**Huntlee - Stage 1 Modification 14 (MP 10_0137 MOD14)
Request for Additional Information**

I refer to the additional information provided for the Huntlee MOD 14 (MP10_0137-Mod-14) submitted in November 2021. The information has been reviewed, and comments from BCD and Council were received and are enclosed. After careful consideration, the Department requires the following additional information:

Figure 3 Required APZ for the large lot site

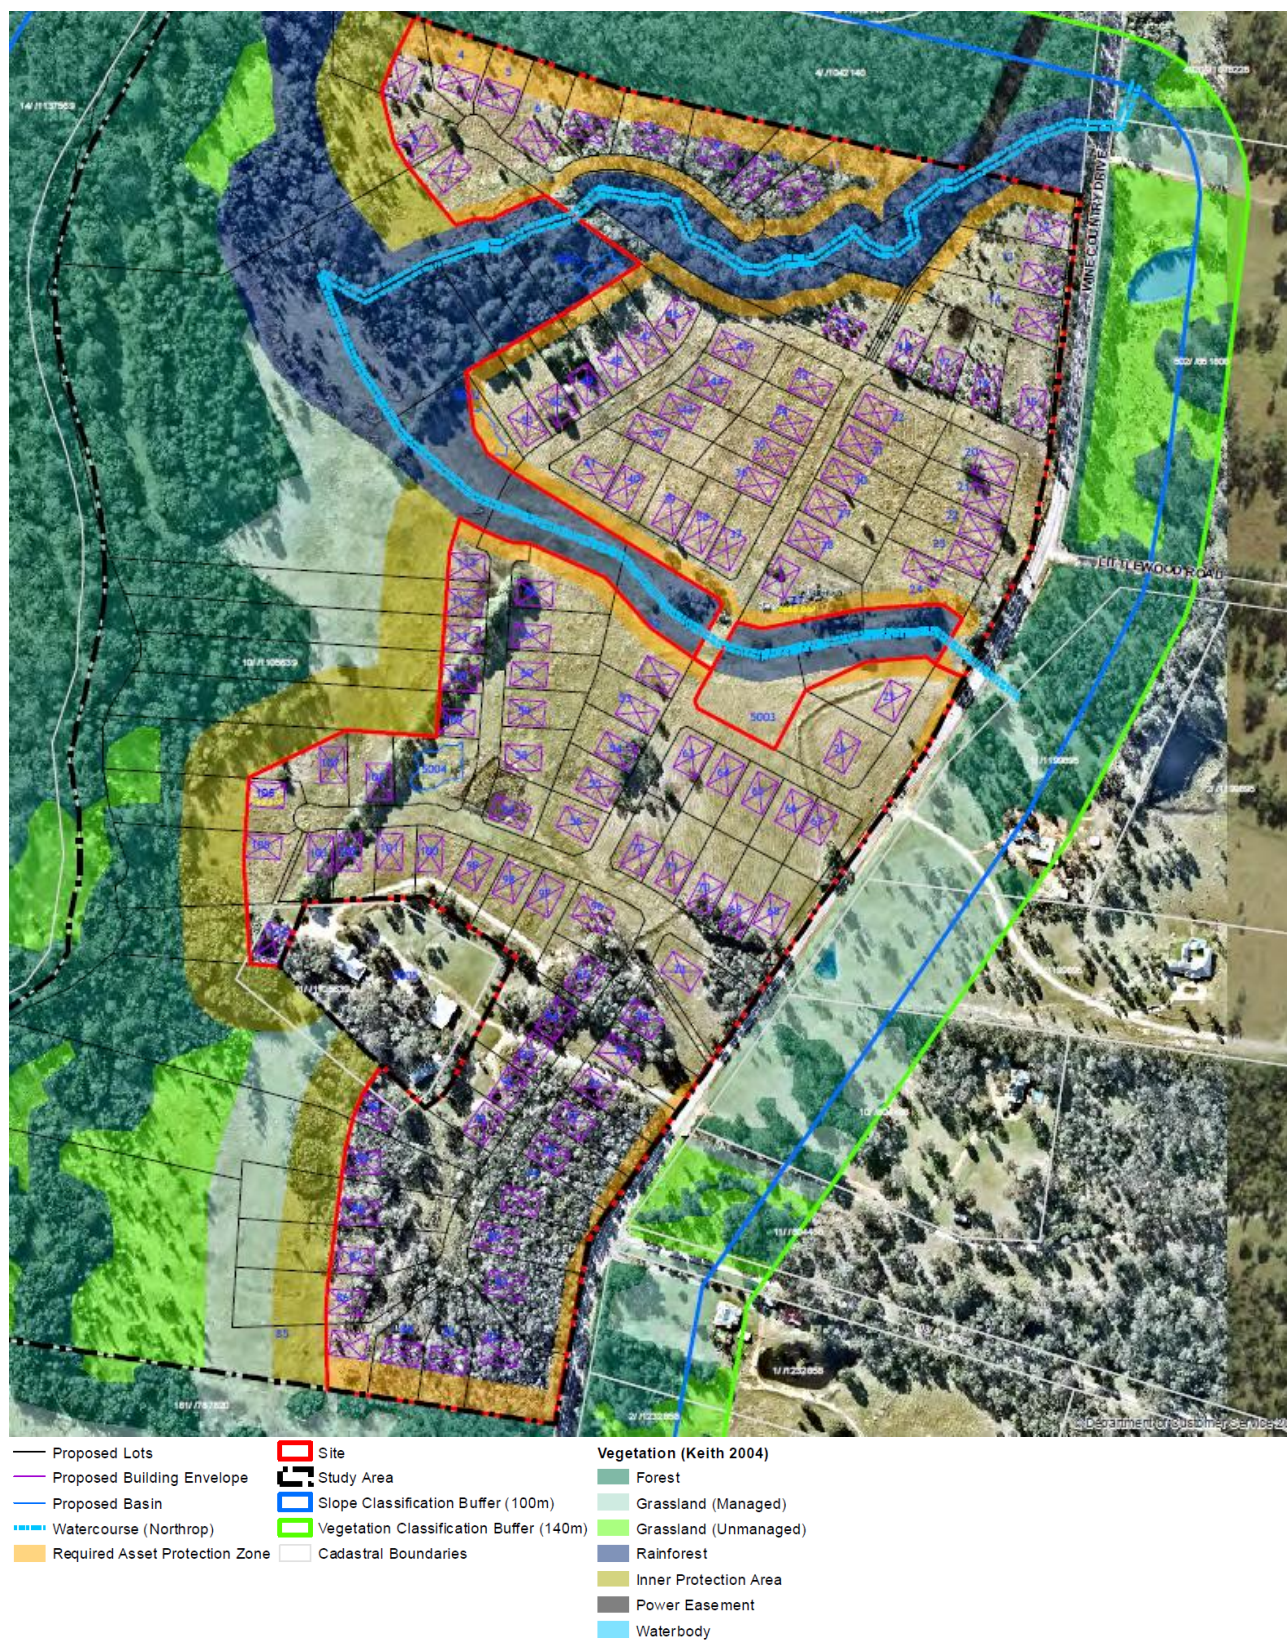
- An overlay clearly showing the approved and proposed subdivision layout against Figure 3-2 of the Huntlee New Town Endangered Ecological Communities from the 2010 Ecological Assessment Report prepared by RPS.
- A plan demonstrating that building envelopes on the private lots in the areas with Central Hunter Riparian Forest and Central Hunter Ironbark- Spotted Gum- Grey Box Forest that were previously open space could be located outside of the areas of EEC.
- Updated documentation, including 'Figure' on page two of the MJD Environmental letter (dated 29 October), removing any encroachment of the Asset Protection Zone (APZ) into the buffer required under Condition C9(c) and C10.

DRAWING TITLE: **1 TO 3000(MOD14)**
 PROJECT: **HUNTLEE STAGE 1 - DEVELOPMENT AREA WINE COUNTRY DRIVE, HUNTLEE**
 CLIENT: **HUNTLEE PTY.LTD.**

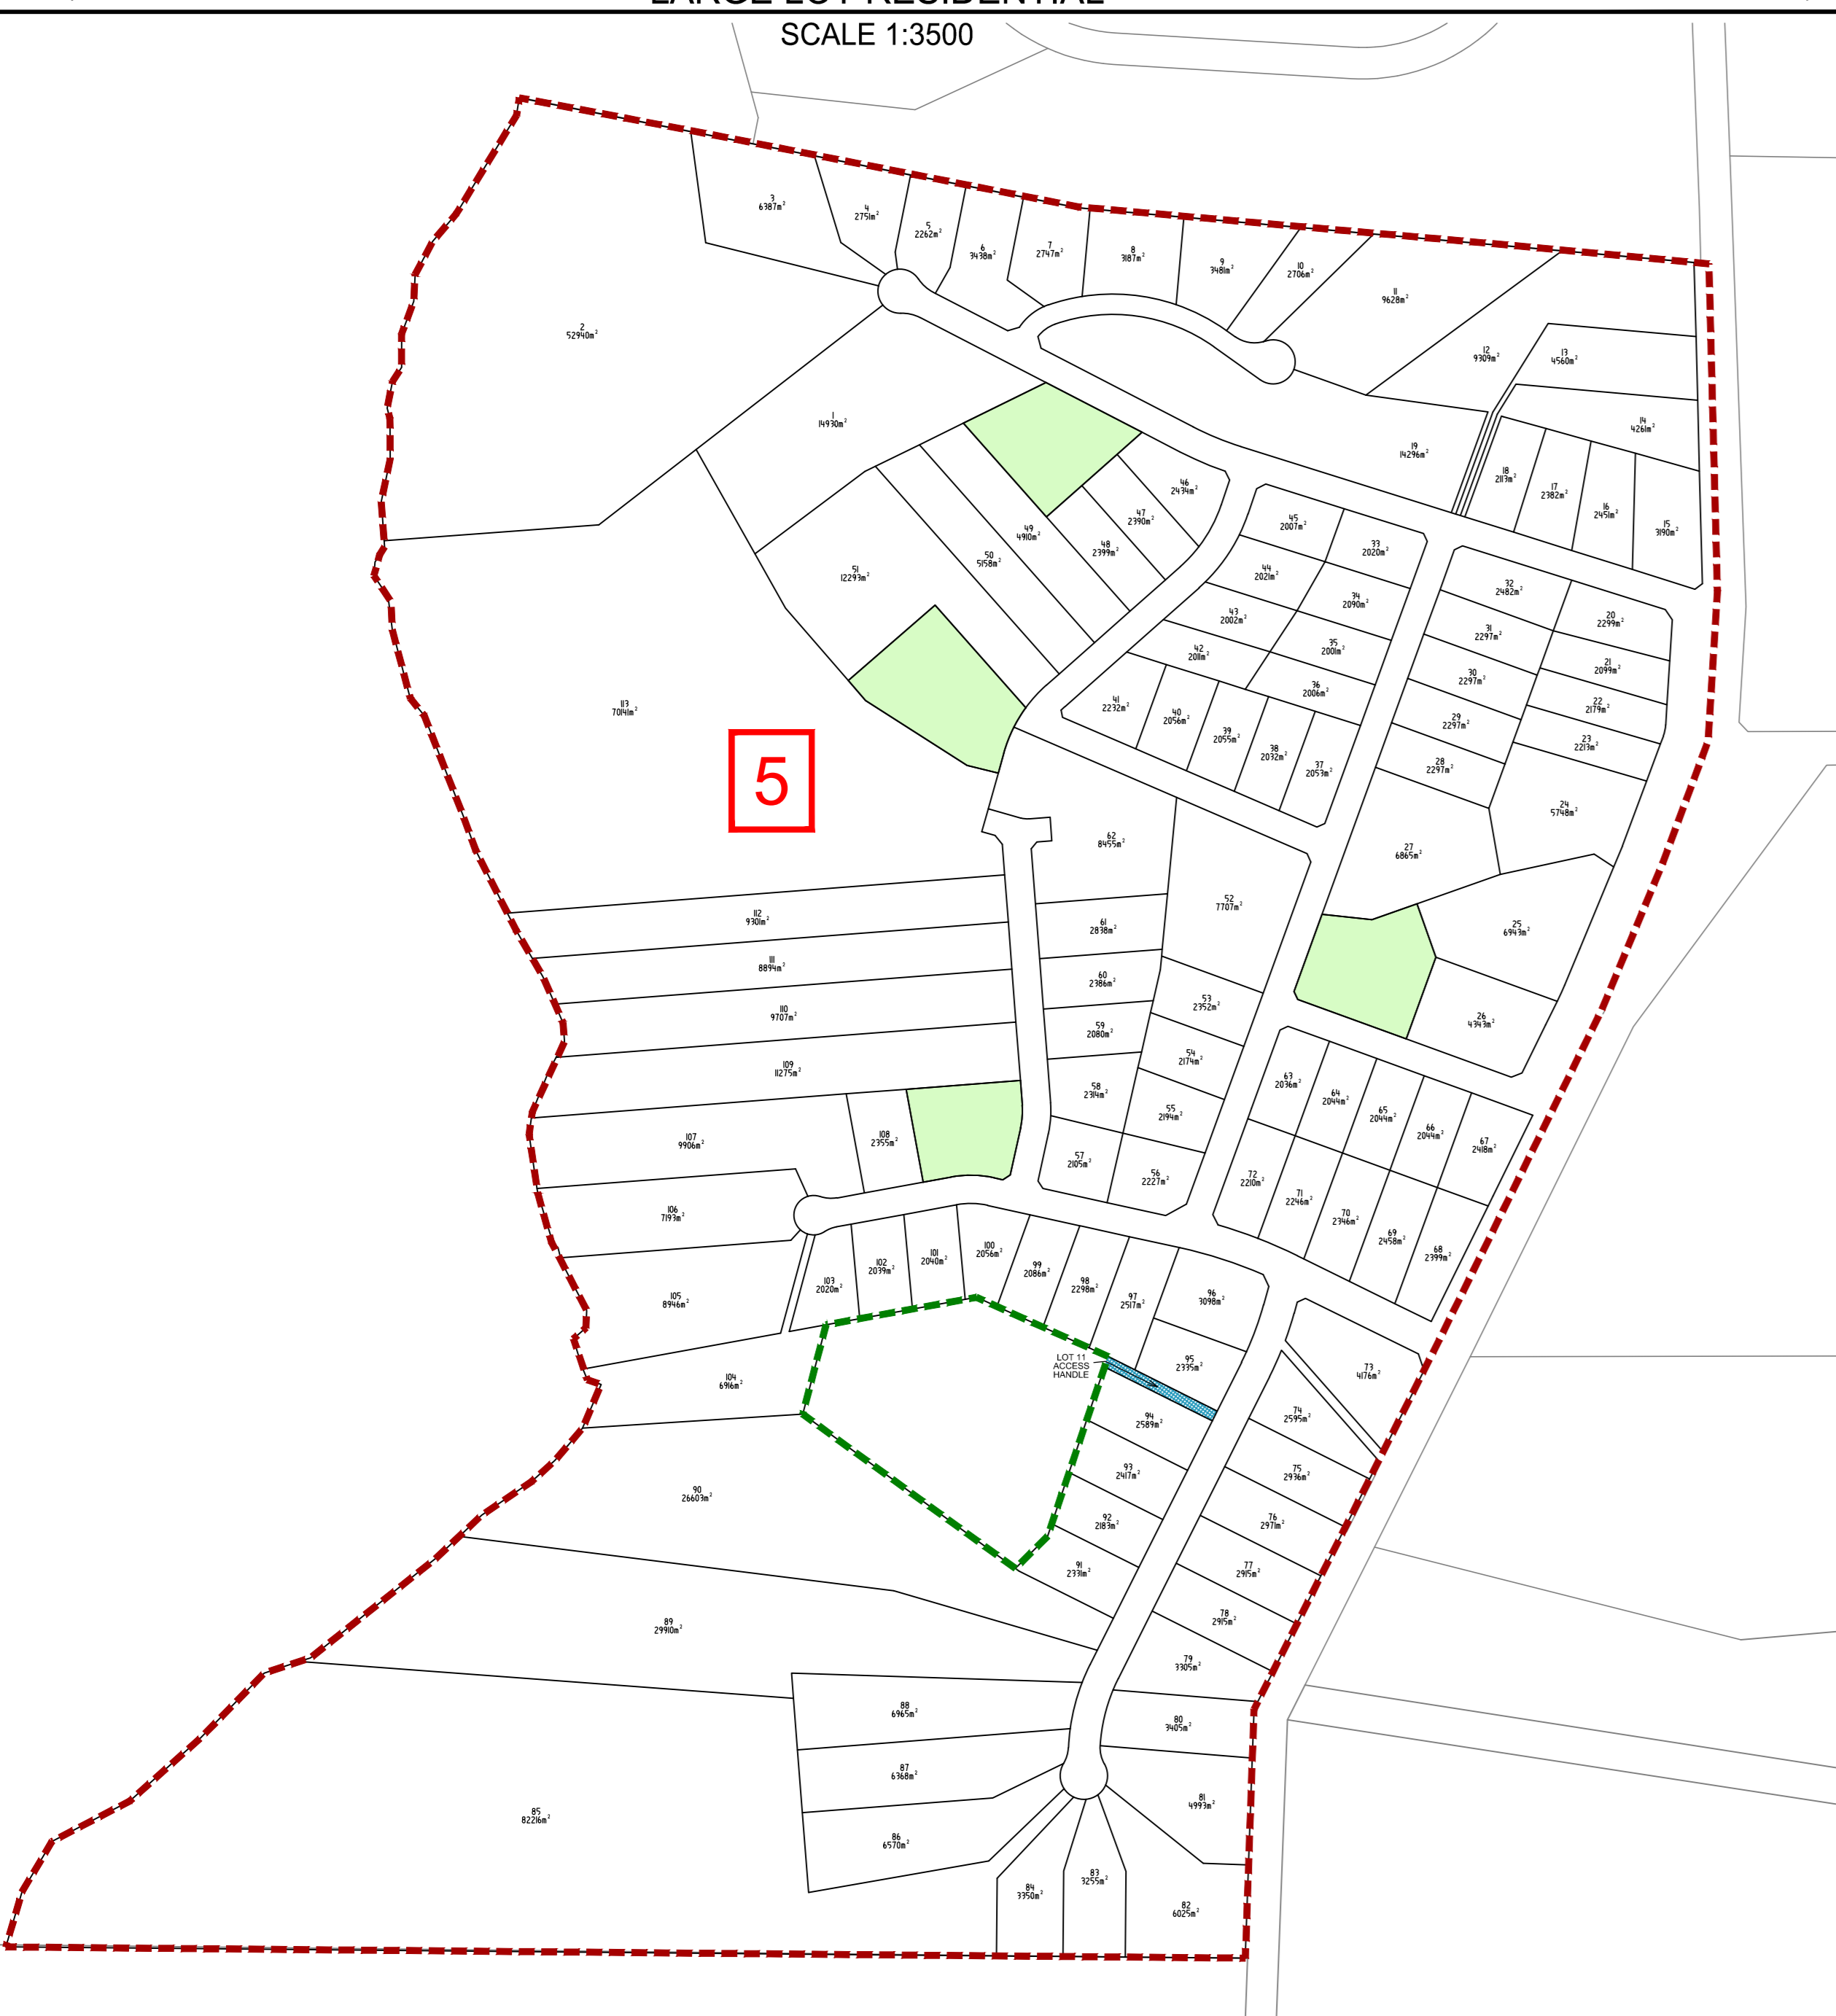
It is noted that the areas of Central Hunter Riparian Forest and Central Hunter Ironbark- Spotted Gum- Grey Box Forest do not form part of the conservation measures secured under the VPA. However, the areas within Large Lot Stage 5 were largely included in open space, and are now proposed within private lots. Therefore, an assessment of the impacts is required, including:

Council PMF Flood Depth and Extent

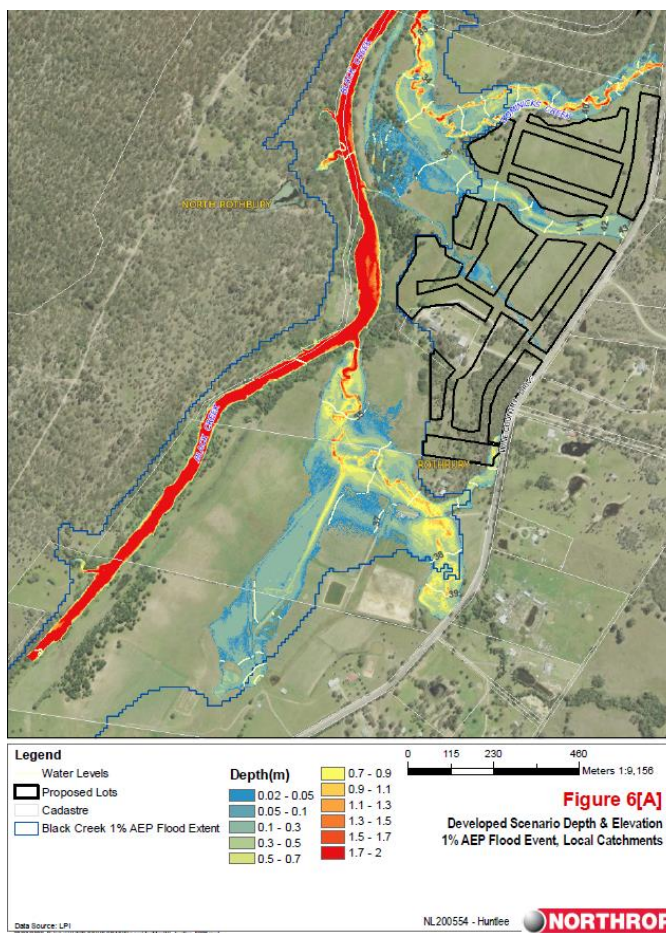
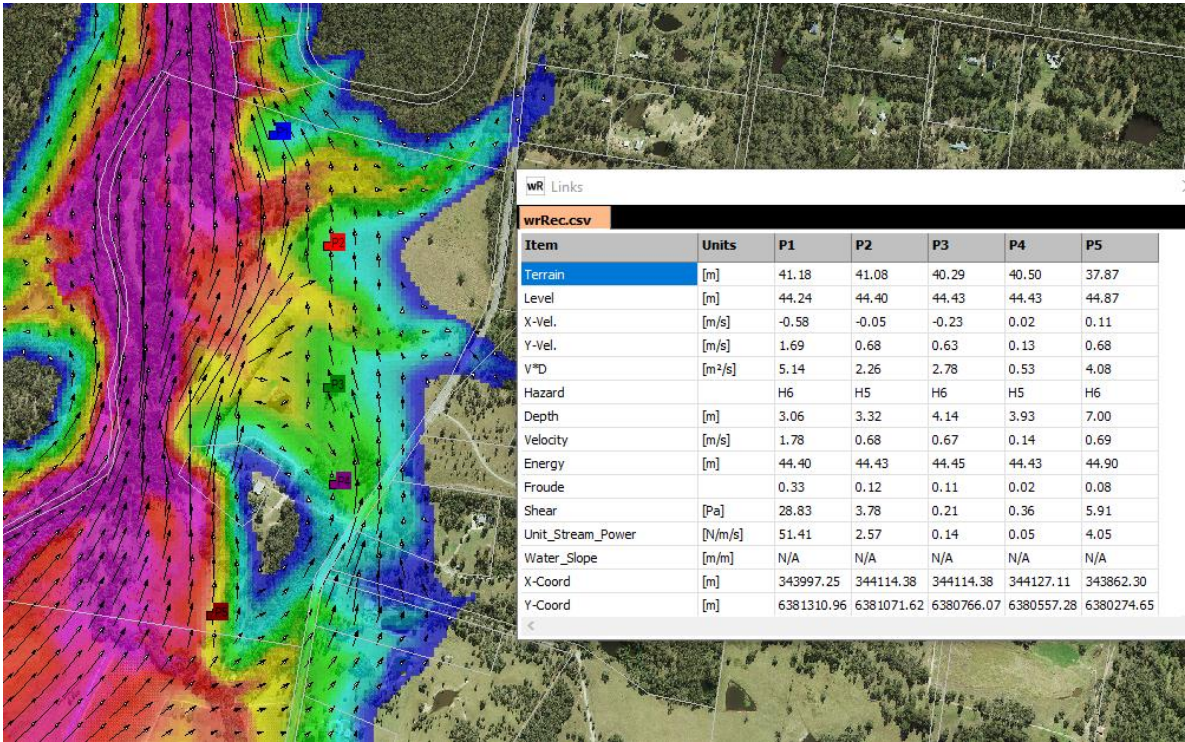
- Revised flood maps demonstrating that the subdivision is designed so that flood-free access is provided to all lots for the 1% AEP event. Rising road access is also required to permit evacuation of the area to a place of safety for all events up to and including the PMF event.
